**KIRKLEES METROPOLITAN COUNCIL
INVESTMENT & REGENERATION SERVICE**

DELEGATED DECISION TO DETERMINE PLANNING APPLICATIONS

Reference No:	2023/62/92374/W
Site Address:	54, Newsome Road, Newsome, Huddersfield, HD4 6NQ
Description:	Erection of two storey side extension and front and rear dormers
Recommending Officer:	Luke Walstow

DECISION – REFUSED

LOFT

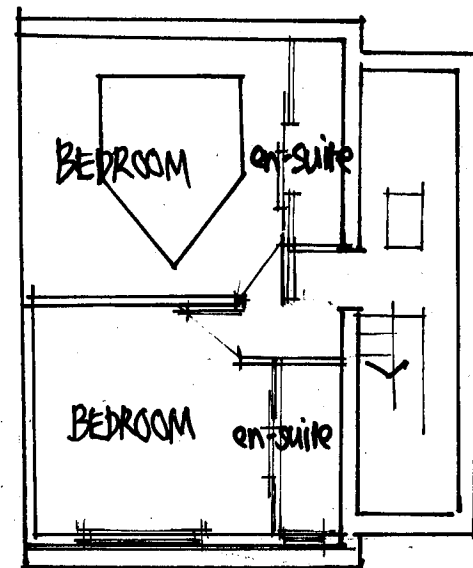
The proposed front dormer does not relate to the appearance of the house or its roof and is within an area where front dormers are not part of the streetscene to this type of property, although they are present to older dwellings on the other side of the road. It would appear as a sizeable and incongruous feature to this dwelling and within the wider roofscape. It would be located off-set from the windows below and not in a symmetrical location within the roof. It would cause harm to visual amenity, contrary to Policy LP24 (a and c) and the SPD.

The rear dormer, whilst large, does to some extent represent development that could be undertaken utilising 'permitted development rights' (subject to materials).

FRONT ELEVATION

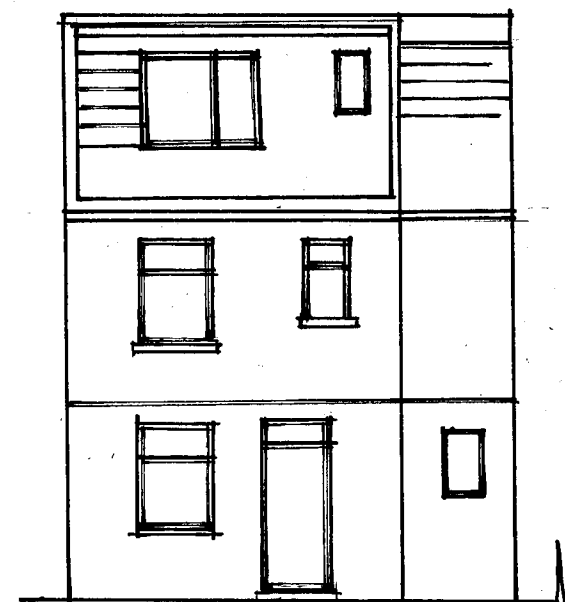
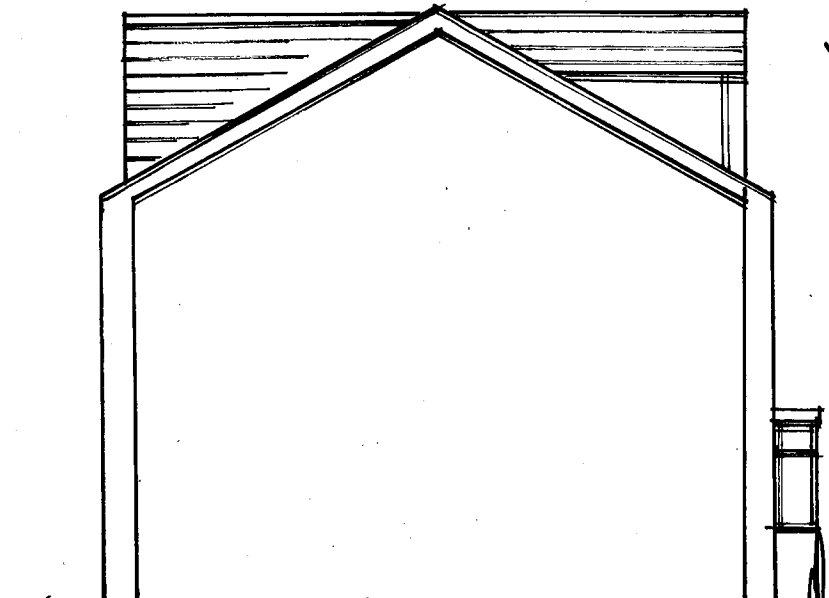
The proposed extension would be constructed from similar materials as the host dwelling, whilst this is appropriate, it would however take up most of the space to the side of the dwelling, with no 1-metre separation gap to the neighbouring property. Whilst it is almost 500mm from the front wall (~0.46 metres) there is no clear visual break when viewed from the front, which is compounded by the roof design (gable not hipped). It would visually appear adjoined to the neighbouring property’s boundary and would appear incongruous in the wider streetscene. As no. 54 is stepped forward of no. 56 to the south, and the siting of the application property is on rising land, the side extension and gabled roof form would be overtly visible within the streetscene and would be a detrimental feature to the visual amenity of the area. The proposed side extension would be visually harmful to the host property and the wider streetscene. To this extent the development is contrary to Policy LP24 (a and c) of the Local Plan and the adopted SPD.

1. The proposed development by reason of siting, design and scale of the two-storey side extension and the front dormer, would cause harm to the visual appearance of the host property and the wider character and appearance of the street scene. To approve the development would be contrary to Policy LP24 (a and c) of the Kirklees Local Plan, Key Design Principles 1 and 2 and paragraphs 5.20 and 5.27 of the Council's adopted House Extensions and Alterations SPD and Policies contained within Chapter 12 of the National Planning Policy Framework.
